**Pick n Payless Metal Recovery and Recycling Facility (SSD-8375)
Response to Submissions**

PICK N PAYLESS METAL RECOVERY AND RECYCLING FACILITY (SSD-8375)
DEPARTMENT OF PLANNING, INDUSTRY AND ENVIRONMENT – KEY ISSUES

Datum: A.H.D.

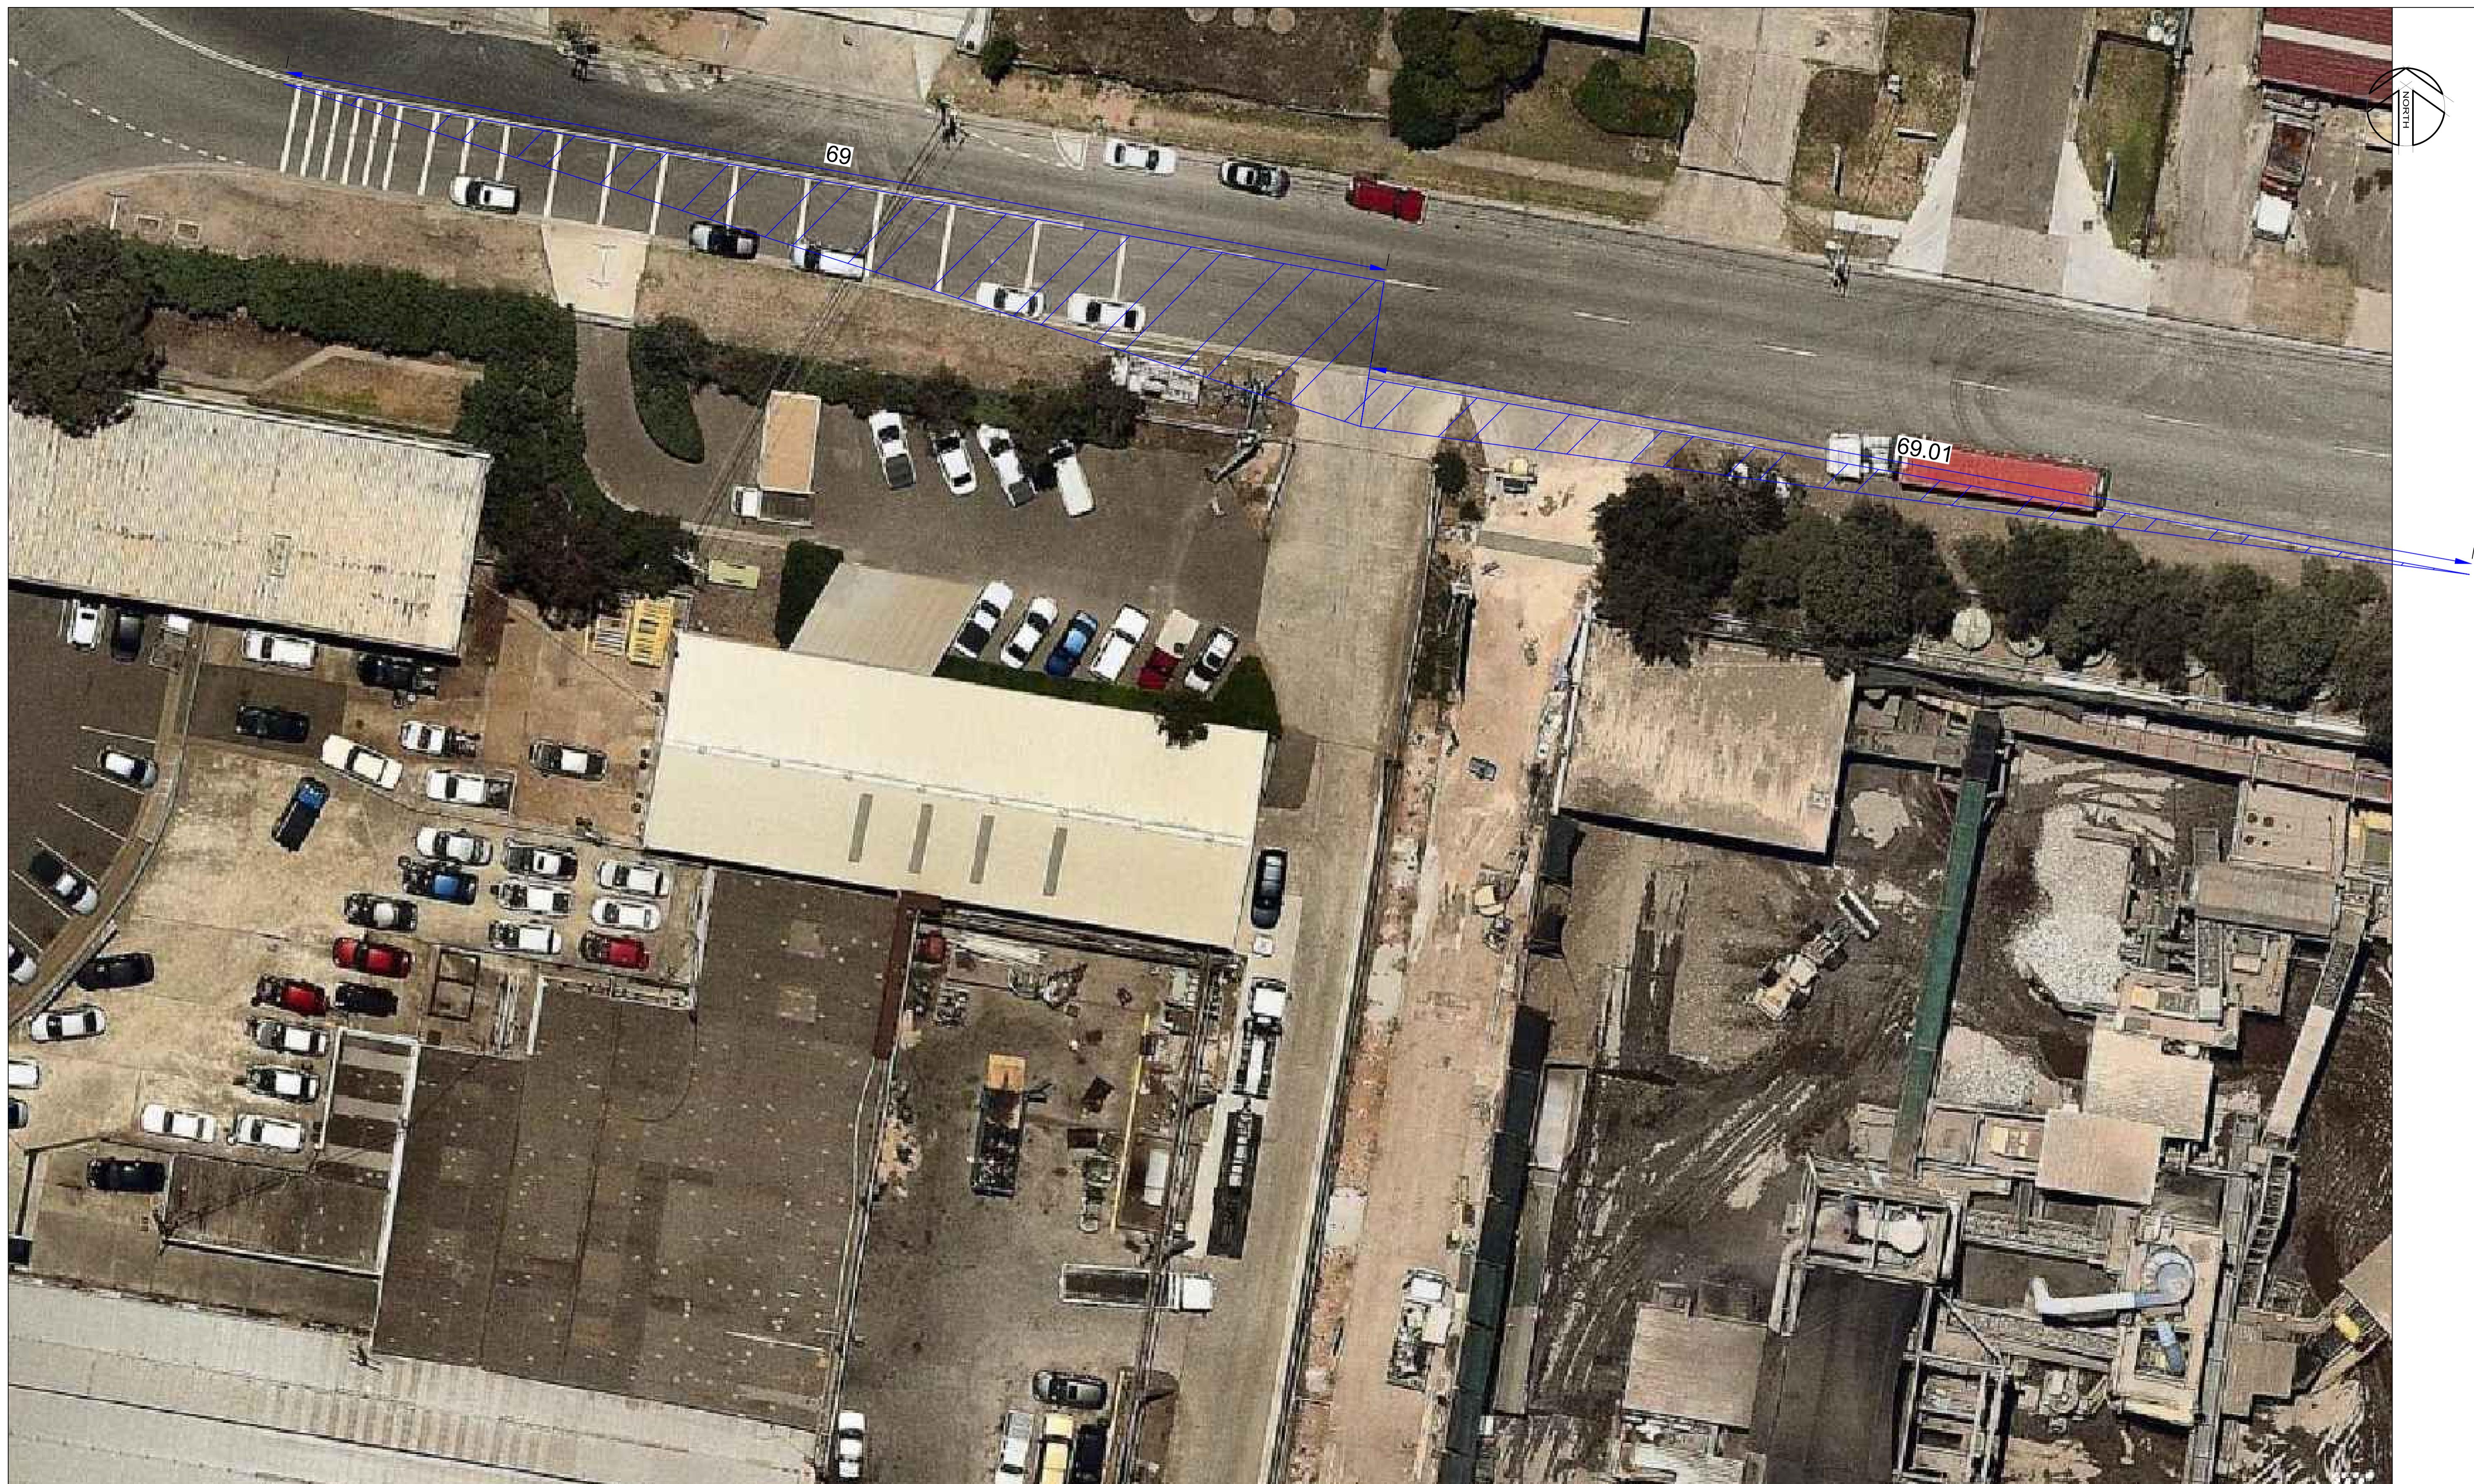
18. The Appendix B Swept Path Analysis of the TIA shows the proposed heavy-duty concrete access road is 4 m wide. This is inconsistent with the Site Master Plan and Fire Engineering Brief which show the proposed access road is 6 m wide. Please clarify the proposed width of the access road.

Figure 2-2: Site Plan

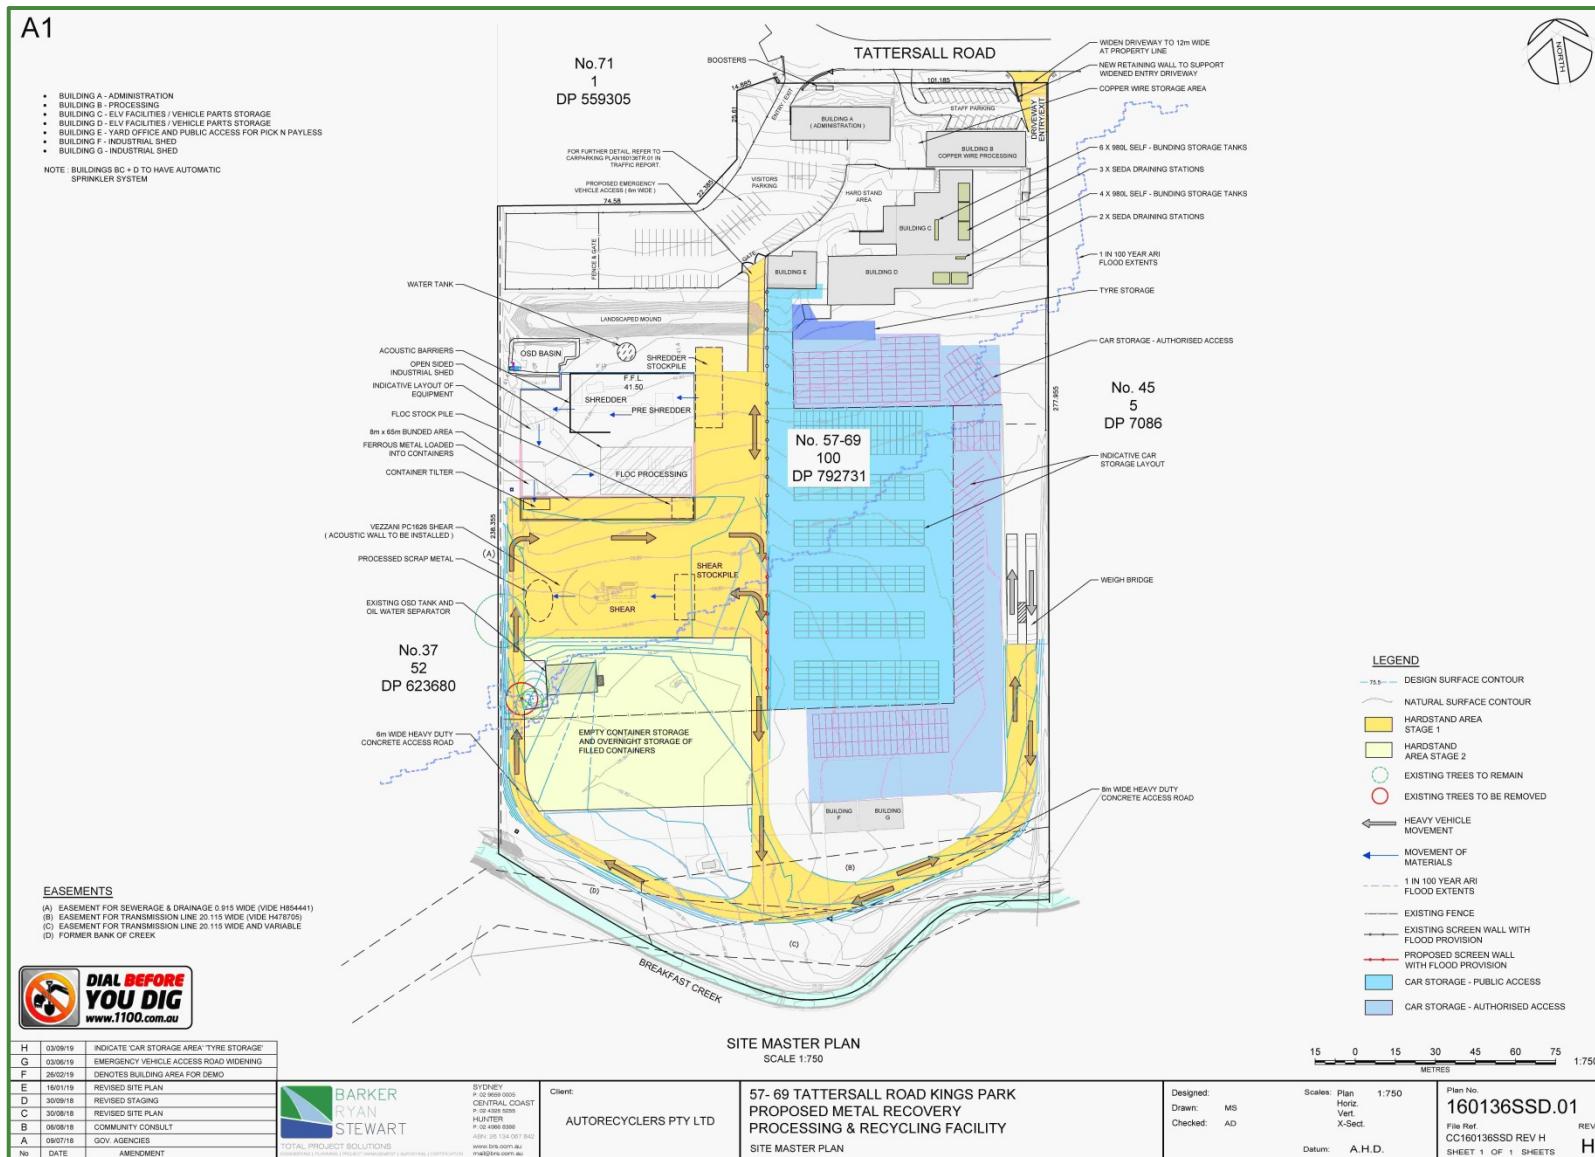
28. Site Plan included in the ENVA is different to the Site Plan shown in Appendix A of the EIS. Please update to ensure consistency between documents.
